Consultation Response from: KC Environmental Health (Pollution & Noise Control)
2020/90862 - Kingsgate Centre, King Street, Huddersfield, HD1 2QB
Discharge conditions 4, 6, 8, 10, 11 on previous permission 2018/93568 for change of use of existing unit in a mixed Class A1/A2/A3 retail development to form a mixed A1/A2/A3/A4/D2 retail and leisure development, internal alterations and reconstruction of upper level, with extension, external slide and formation of roof terrace for use as sky bar
**Date Responded:
05 May 2020**
**Responding Officer:
Richard Hume**
**Responding Ref:
WK/202008128**
Condition 8 – Electric Vehicle Charging points

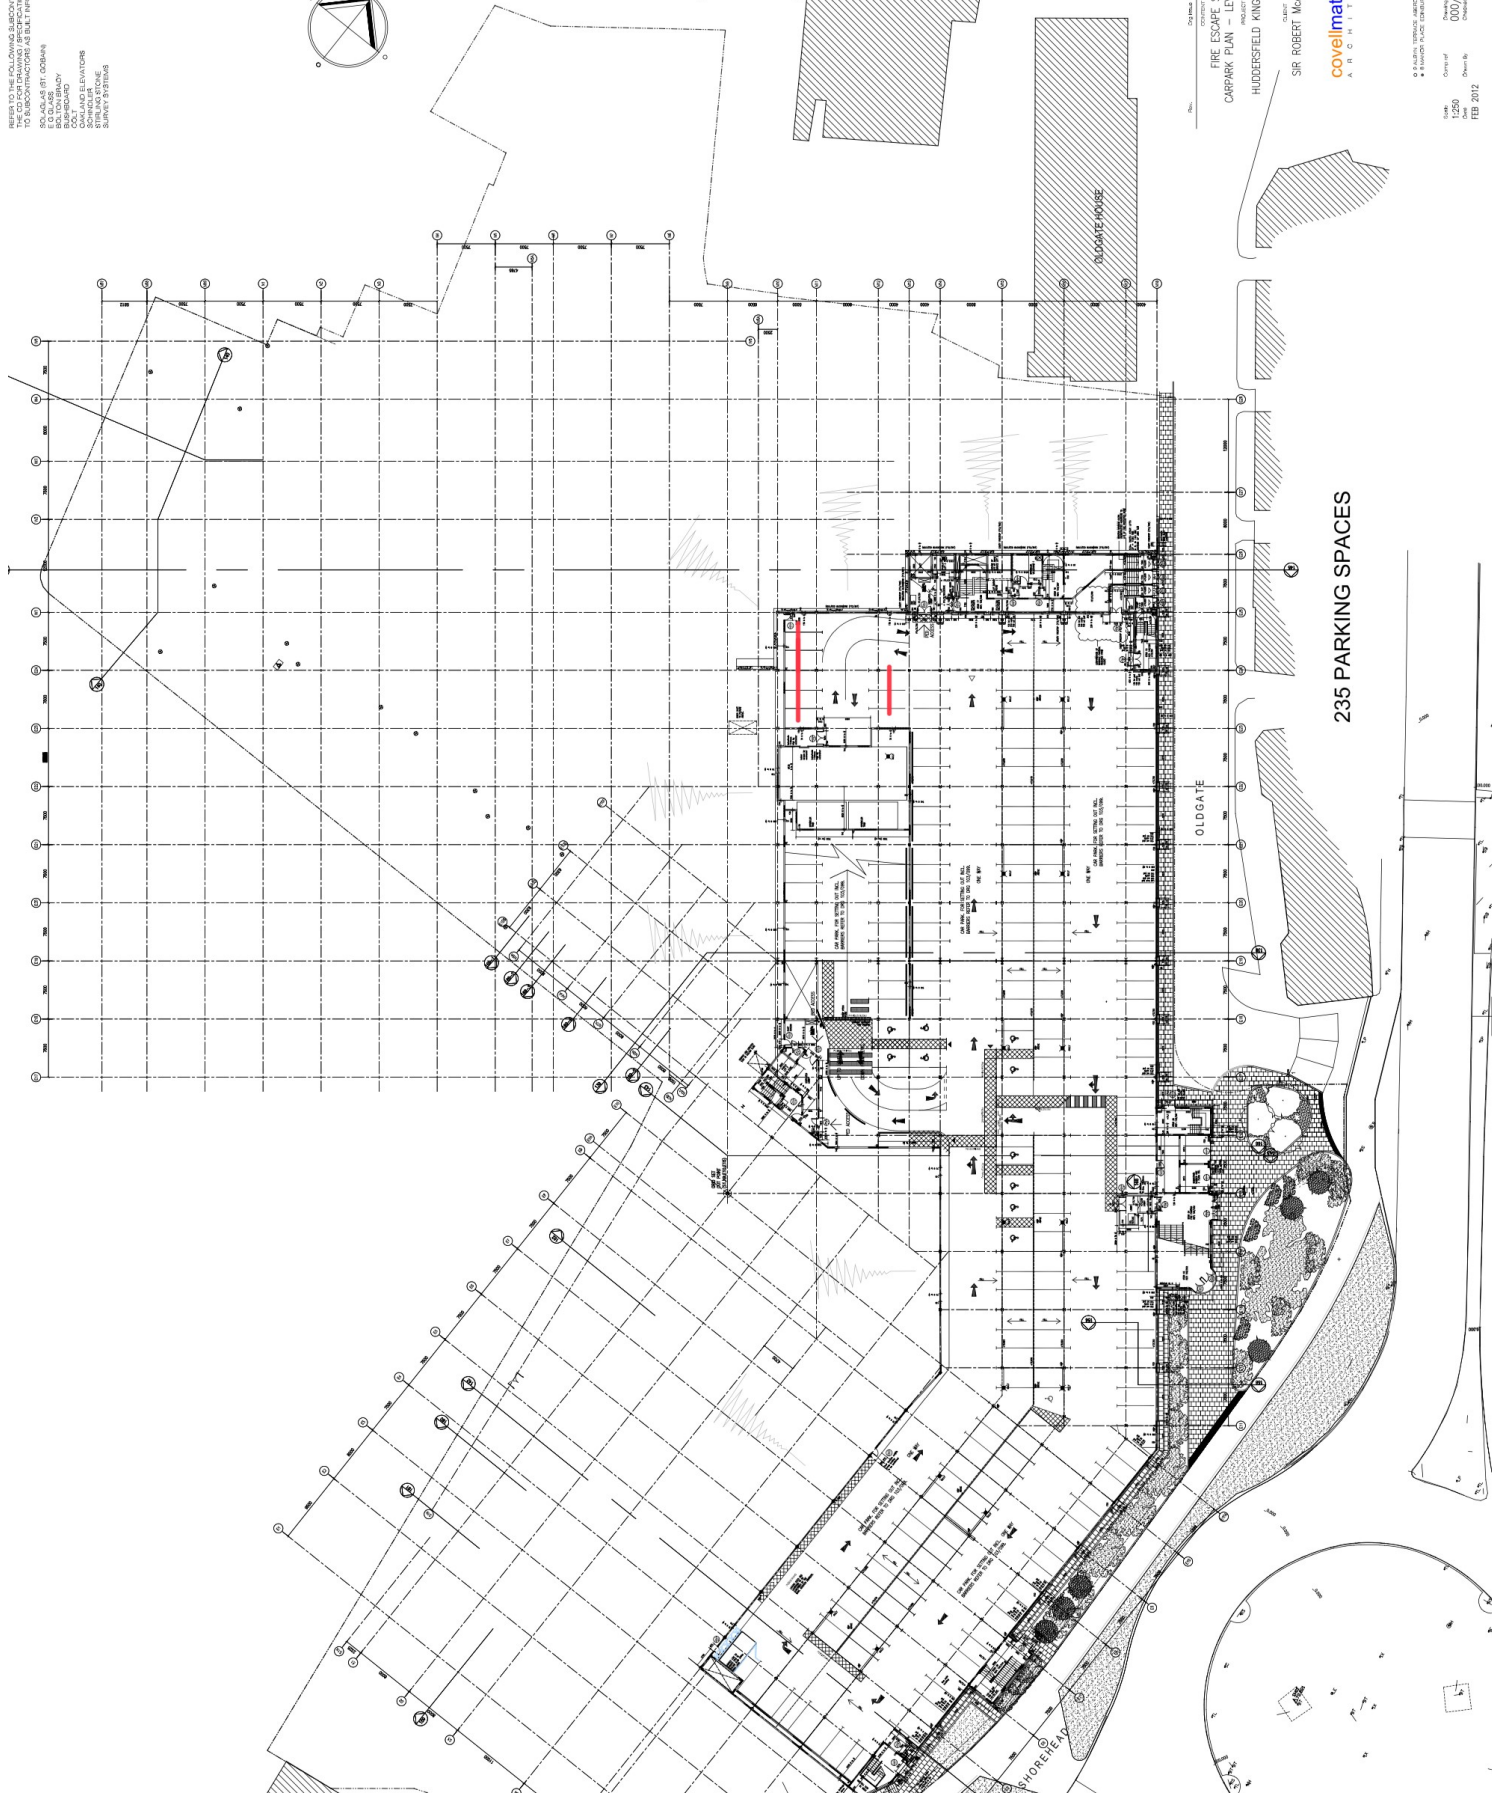
The Planning Condition Statement details the size of the proposed development in relation to the total size of the Kingsgate Centre and proposes charging points for 5% of equivalent proportion of the total parking provision. It therefore proposes the installation of 8 EV charging points at the locations shown on the plan. It advises that each charging point will provide Mode 3 charging via a Type 2 socket with a minimum continuous current of 16A. The manufacturer's information shows two different chargers stating that they are each capable of providing a nominal 22kW per charging point.

The specification of the proposed charging points providing Mode 3 charging at a minimum of 16A via a Type 2 socket is acceptable. The assessment of the number of parking spaces that this condition relates to is considered to be acceptable but we would normally expect a minimum of 10% of the relevant parking spaces to be provided with charging points (or reduced to an initial minimum of 5% that will be increased to 10% at an agreed trigger level). The proposed 8 charging points fall short of the minimum 5% of 178 parking spaces, nine charging points would normally be required. In addition, the applicant has not provided any proposal for the trigger point for when the number of charging points will be increased to 10% of the parking spaces. (i.e. 18 charging points).

It is understood that car park is managed and that users of the car park are subjected to parking fees. It is therefore assumed that the parking bays served by the EV charging points will be managed in a way that prevents them being used by non-electric vehicles.

Confirmation of this needs to be provided by the applicant.

Details of how the use of the parking spaces served by the EV charging points will be managed is required. This should show how these parking spaces will be available for use for charging electric vehicles and not be used for vehicles not being charged.

Details are required for the applicant's proposals for increasing the provision of EV charging points to the required 10% of parking spaces (i.e. a further 10 to make a total of 18 charging points) and their proposed trigger for when this will occur. This should be within a reasonable timescale from when the use of the new development commences, or when the average use of the provided charging points indicates that more charging points are necessary.

Alternatively, if the proposed charging 8 points are to be made capable of providing a continuous 22kW output then no further charging points would be required. The applicant should provide details of their proposals.
